DRB CASE ACTION LOG (PREL/FINAL)

DRB Application No.: 08DRB-70393

Project # 1007459

Project Name: ALBRIGHT-MOORE ADDITION

Plat of  
**Lots 10-A, 11-A & 12-A, Block 12**  
**Albright-Moore Addition**  
 comprised of  
**Lots 10-15, Block 12, Albright-Moore Addition**  
 City of Albuquerque  
 Bernalillo County, New Mexico  
 August 2008

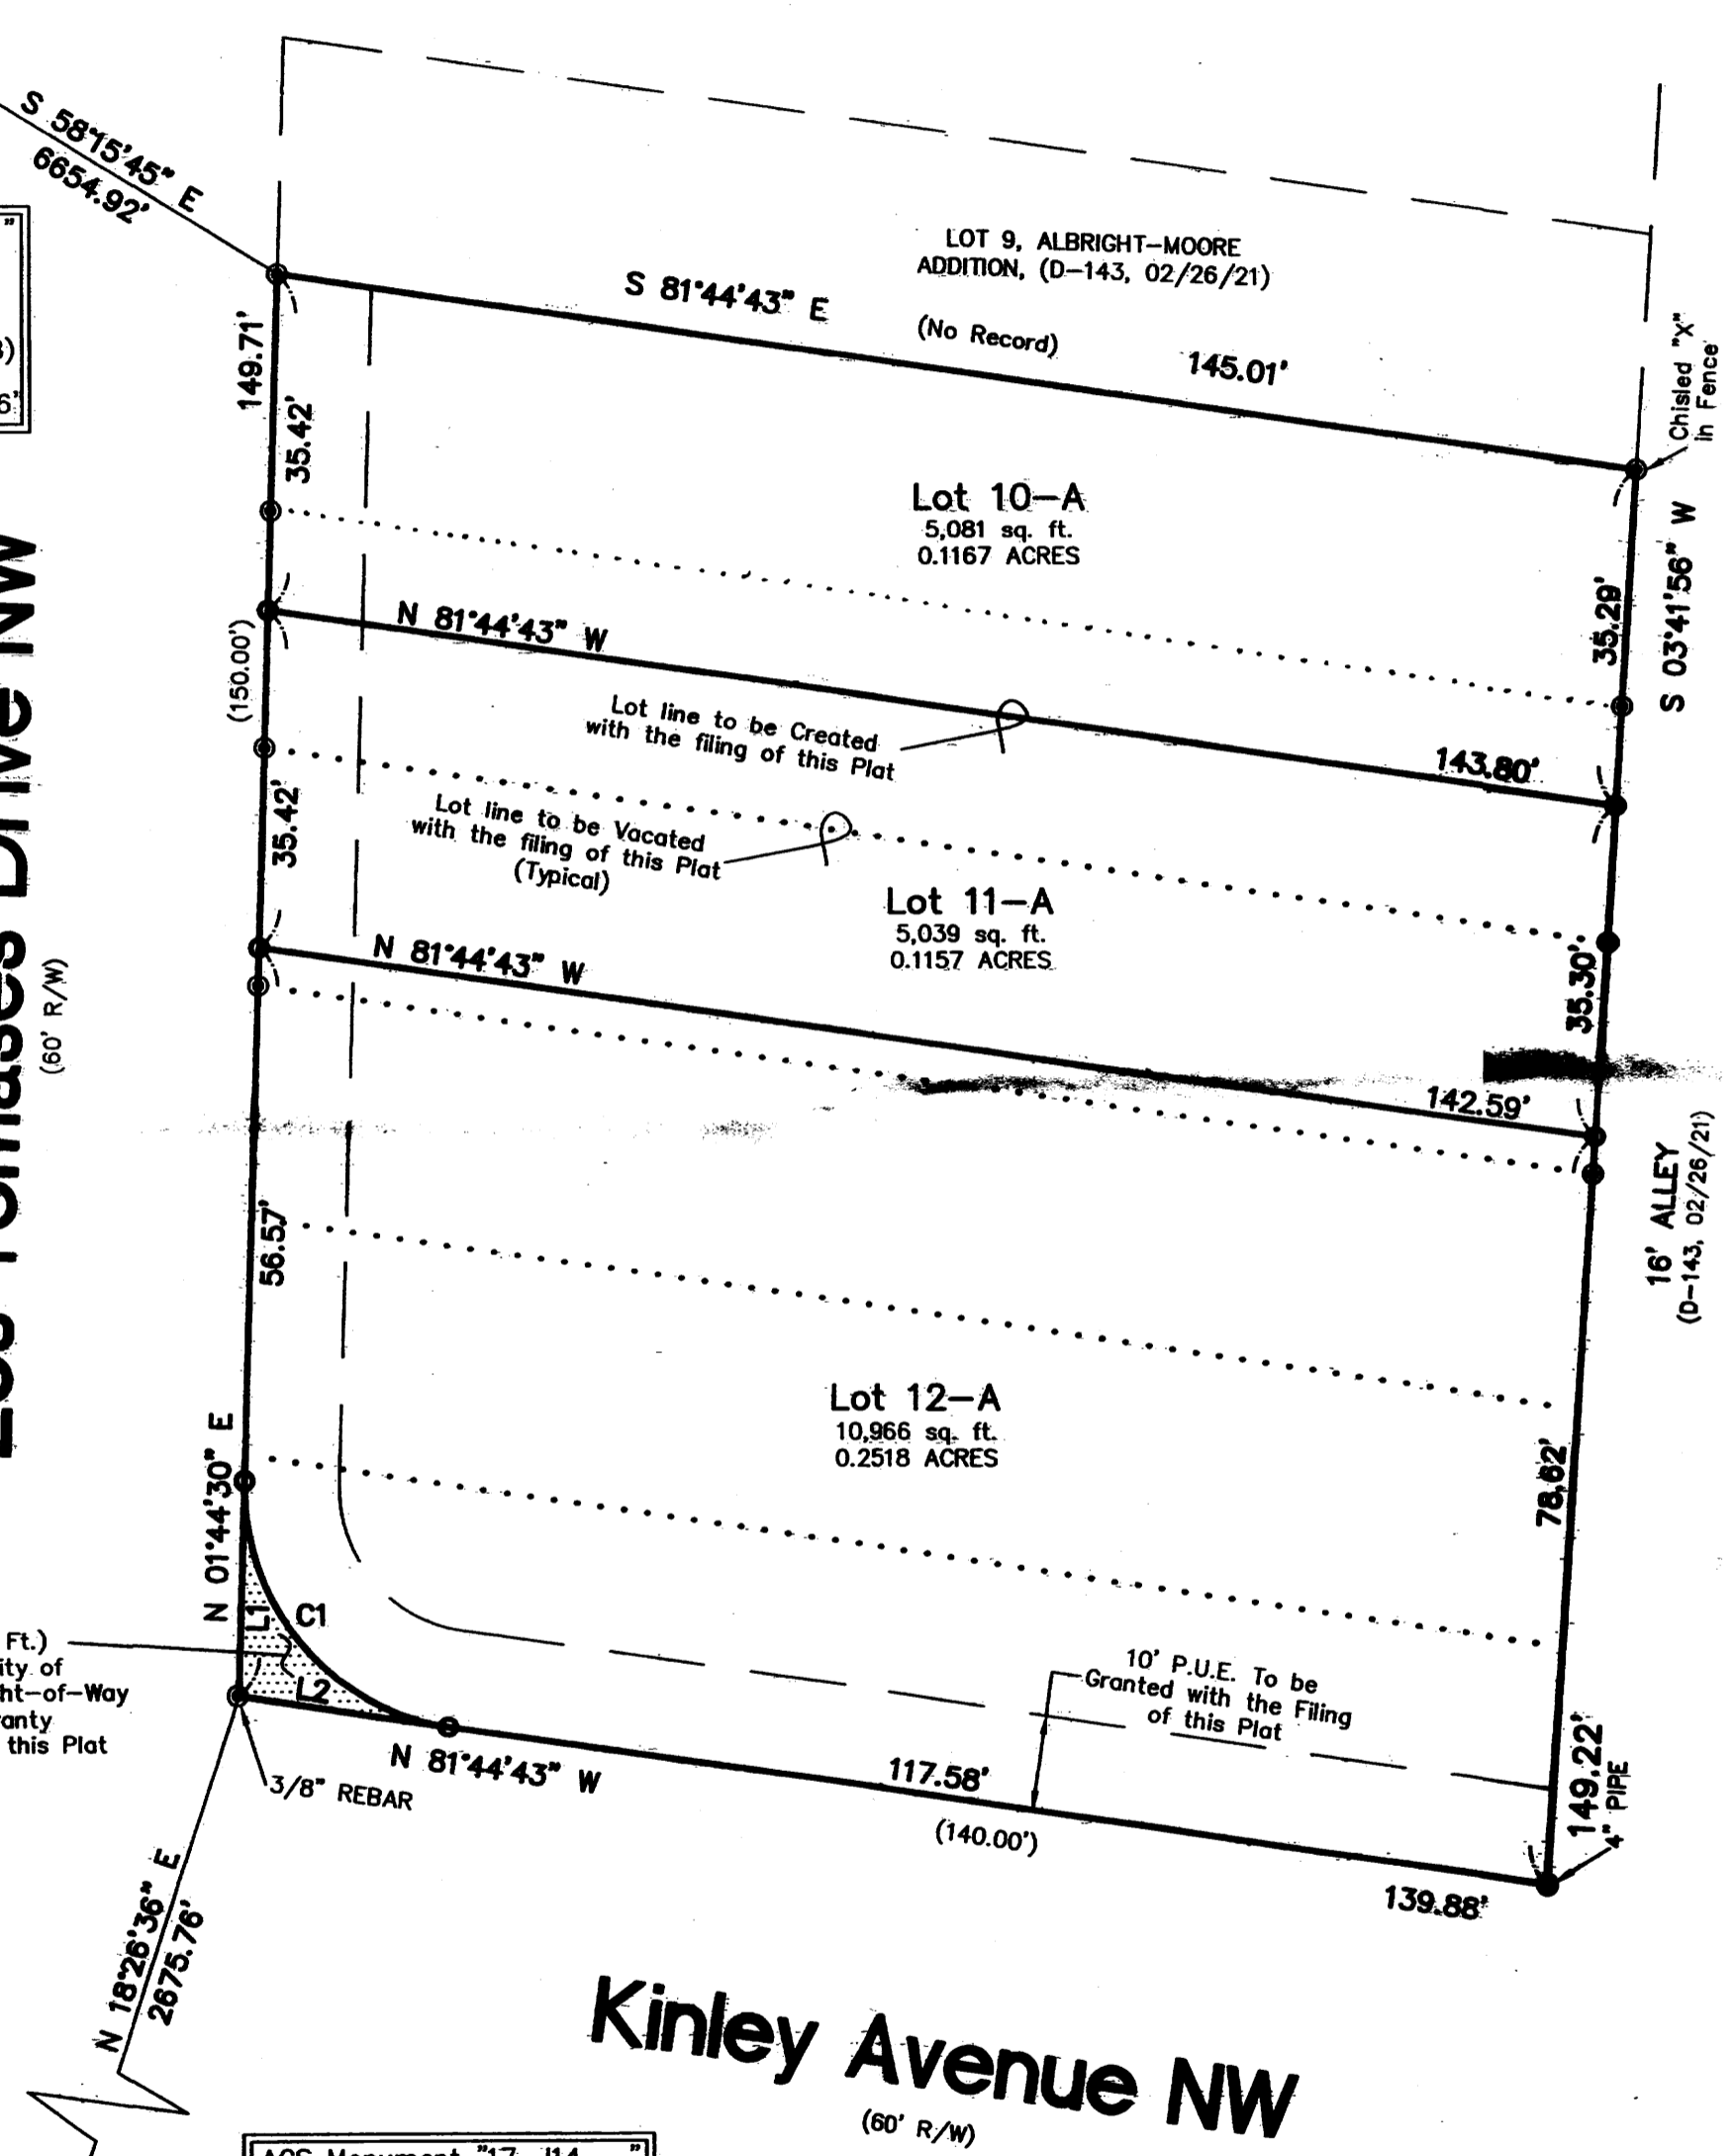
The one story garage and existing wooden fence currently encroaches upon the City right of way. This must be remedied prior to any replat.
